November 14, 2019

**RE: 4-Way Ranch Metropolitan District
Lift Station
Site Development Plan (PPR-18-051) – Comment Response Letter**

Below are comments provided on 05/13/2019 from the review of the Site Development Plan for the above-referenced project. I have inserted my responses and actions taken in **blue** below each comment.

EC1
 SHEET 1 OF 5

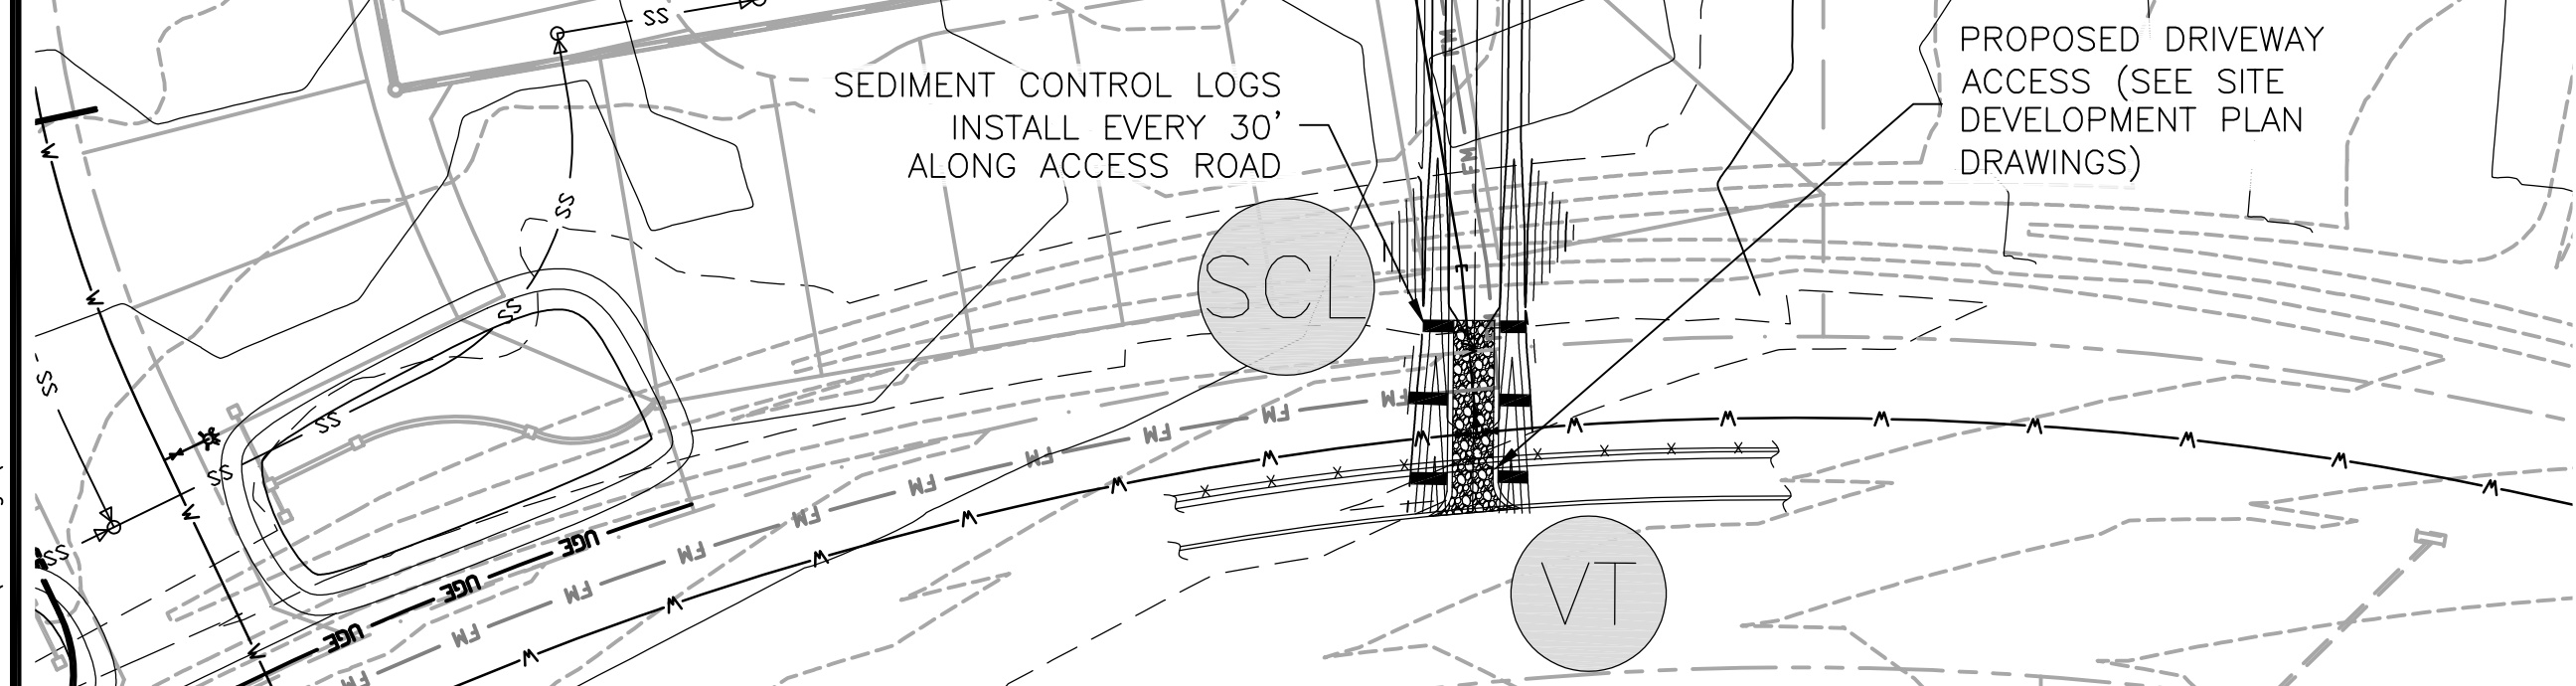
2. Call out the grading and erosion control for both the permanent or temporary SWQ facility, and the culverts and end treatments associated with the access road crossing the drainage way.

Comment addressed in the revised Grading and Erosion Control Plan.

LS1
 SHEET 1 OF 2

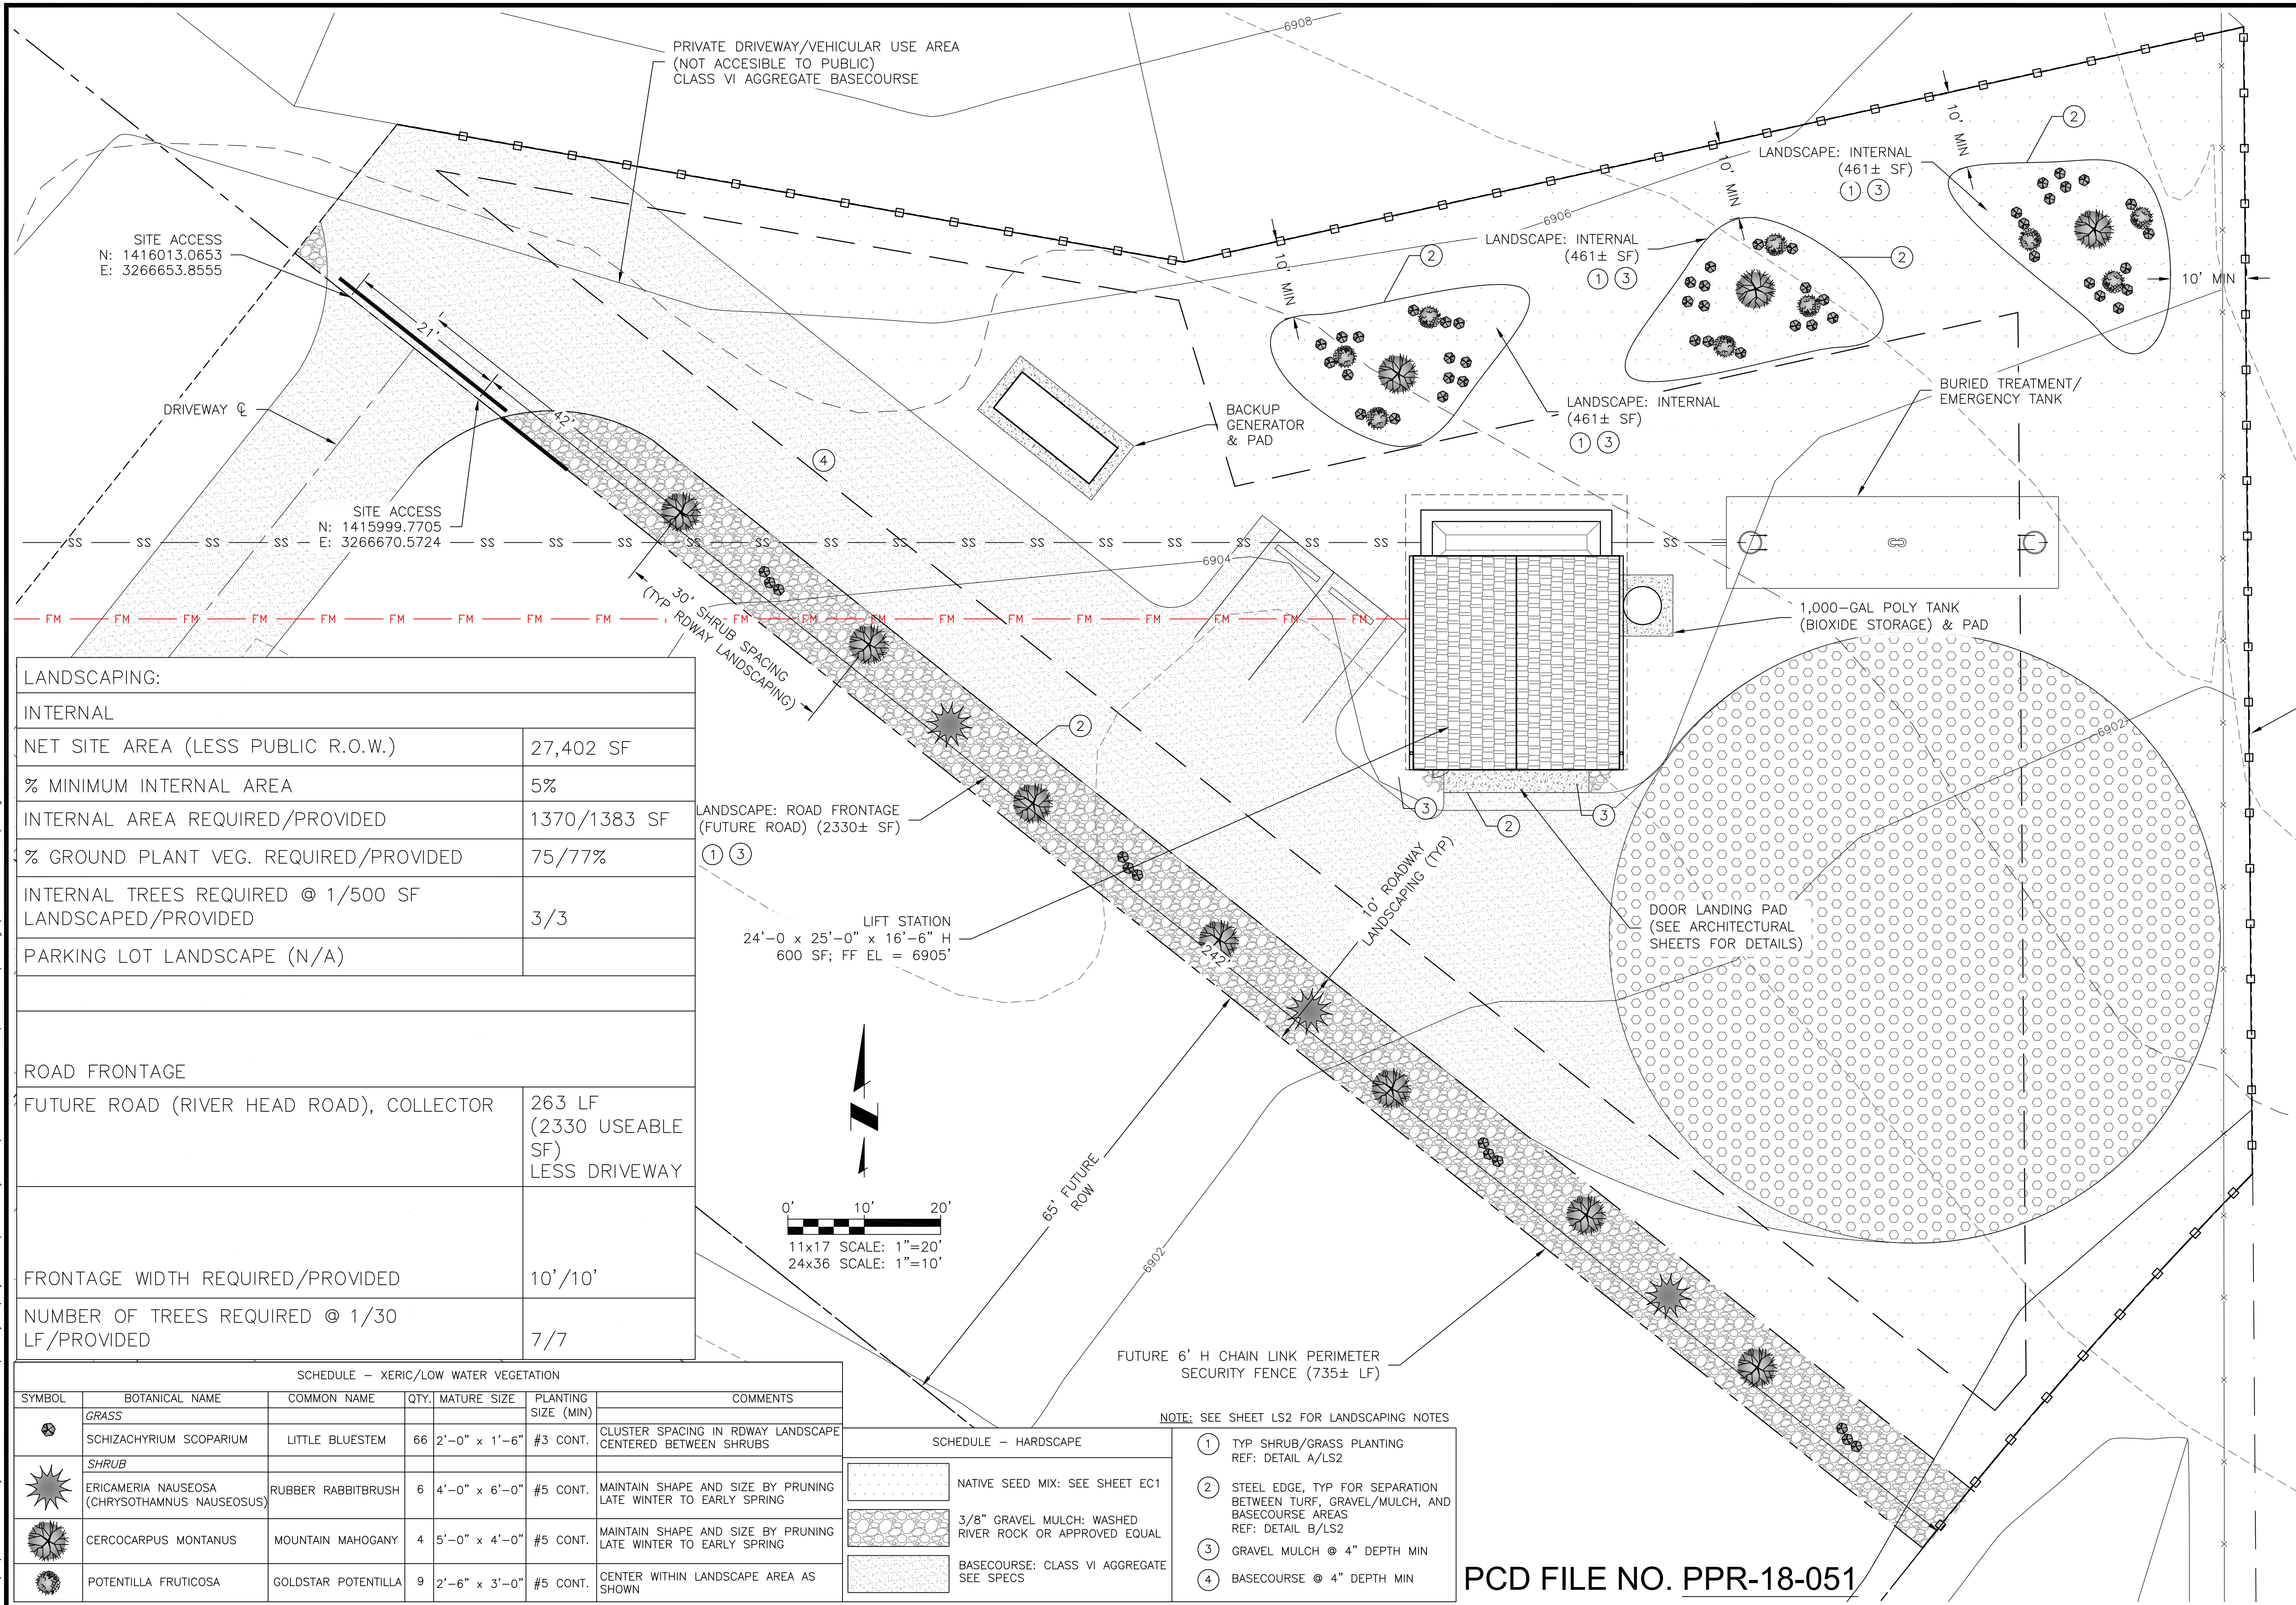
1. Please include a spreadsheet outlining the necessary landscaping in comparison to what have been provided.
A table is provided on Sheet LS1 - Landscaping Plan outlining the required and provided landscaping. Additionally, the proposed landscaping is identified in the Landscape Letter and Letter of Intent.
